Honeycutt Hills Community

Lot 25 – Stonefield 6 Model

AS-BUILT CONDITIONS

M+K Project #: 126-23047 (40/06)

sheet:
S2.0

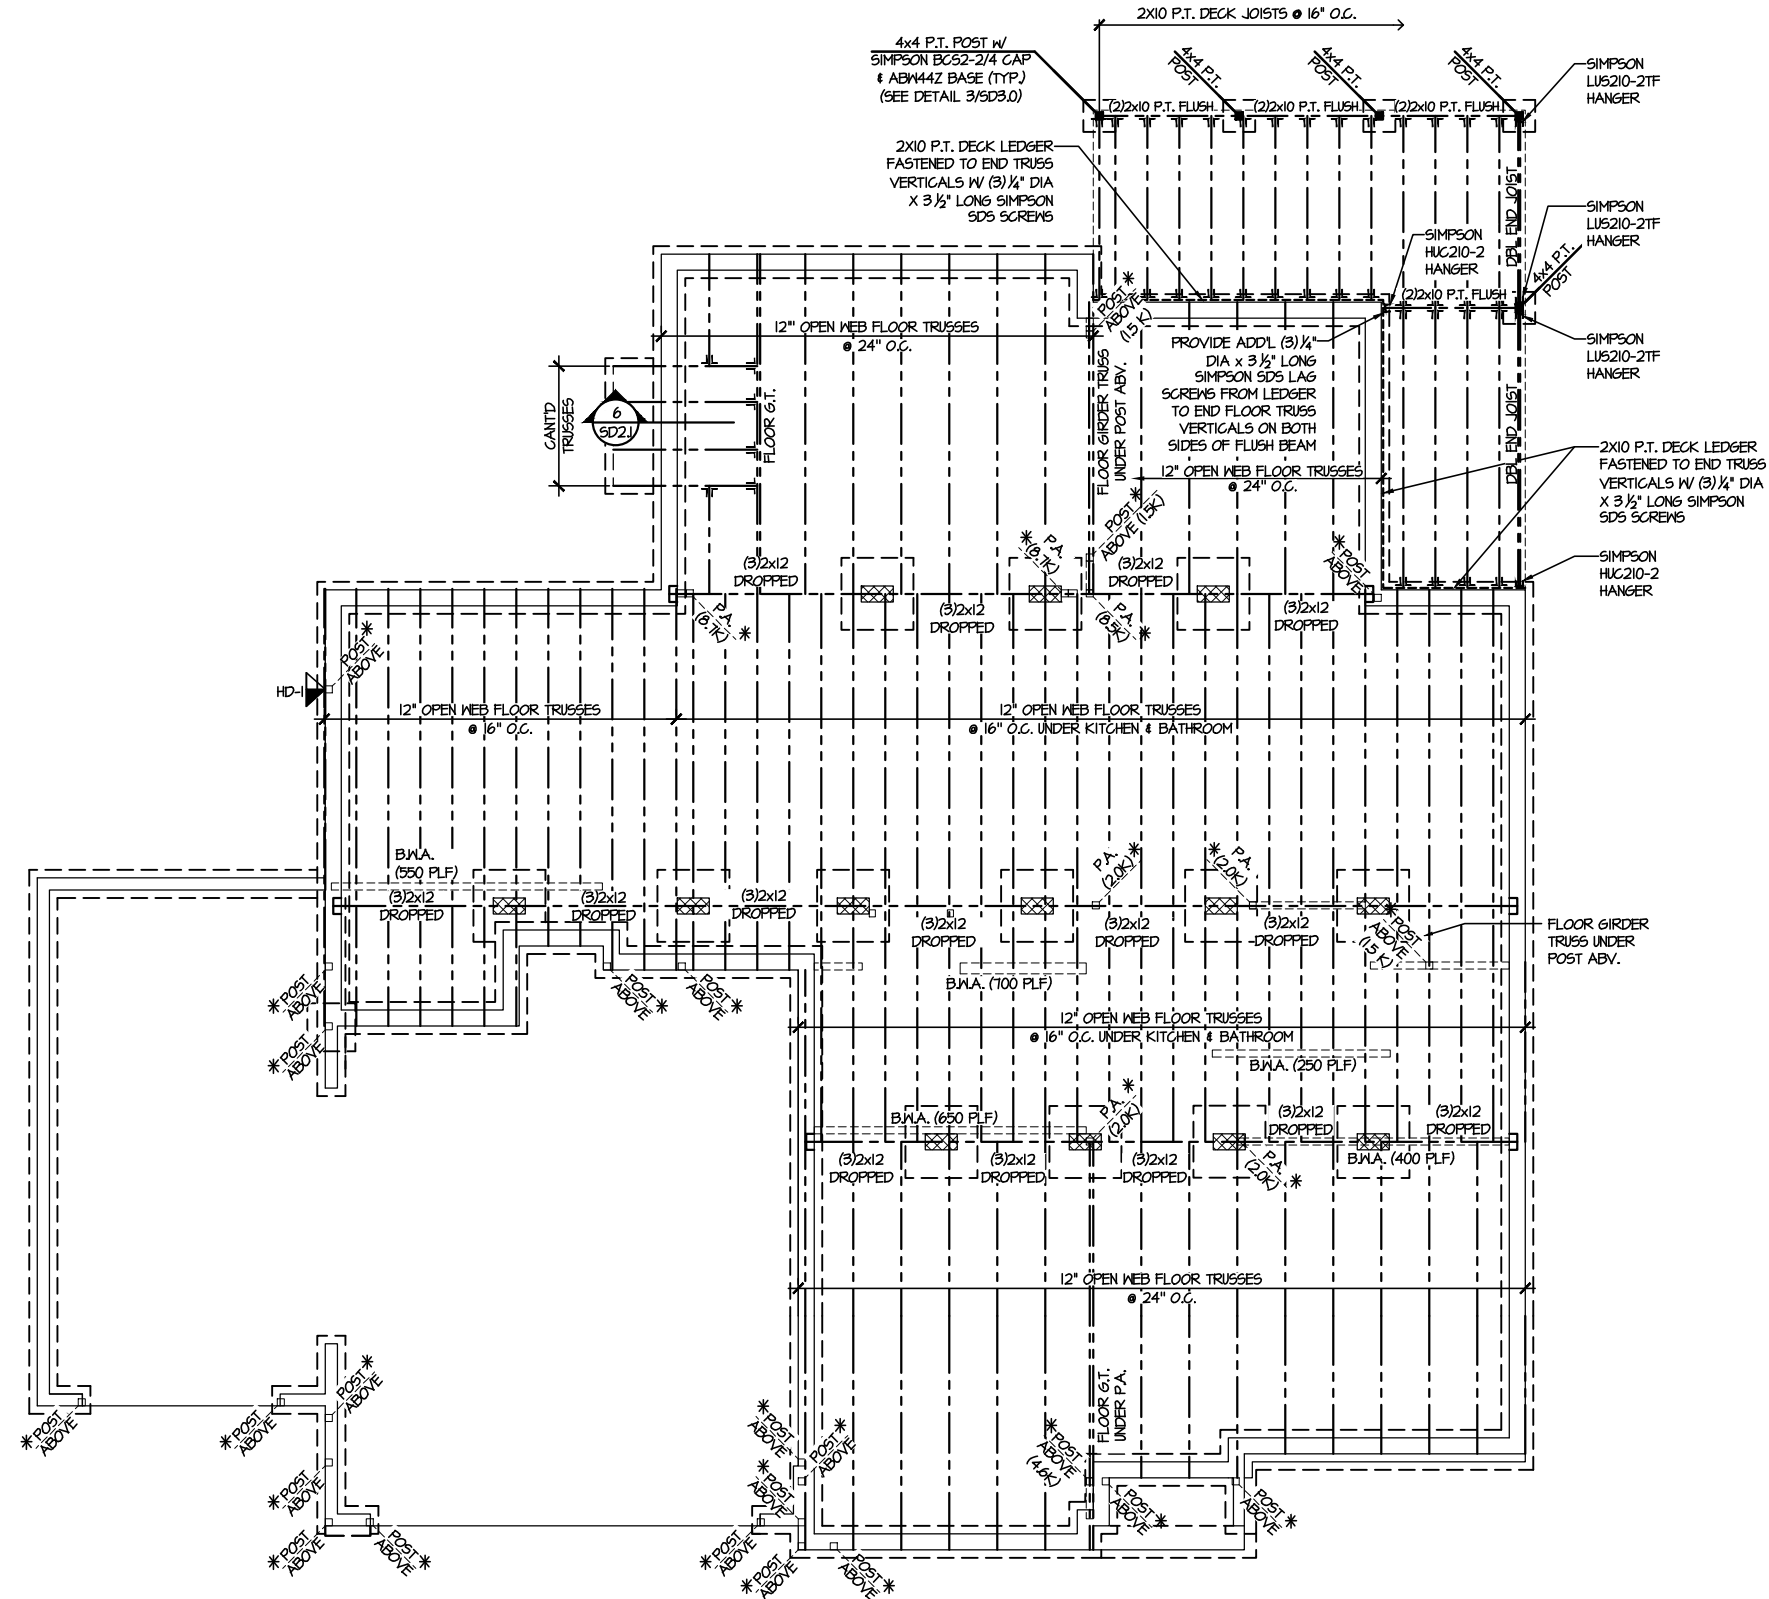
- It was reported to us, by you, that all sets of double or triple windows on the 1st floor were not framed per the structural plans. The structural plans call for (2)2x4 king studs w/ (1)2x4 jack stud each side between each window in a set. Instead, there is only one king stud with a jack on each side between each window.
We have analyzed the as-built condition, and it is our professional opinion that this method is structurally adequate, and no repairs are required. Please note that all triple windows should have at least (2)2x4 king studs on both ends, and the front dining room triple window requires a portal frame across those windows as shown on plan.
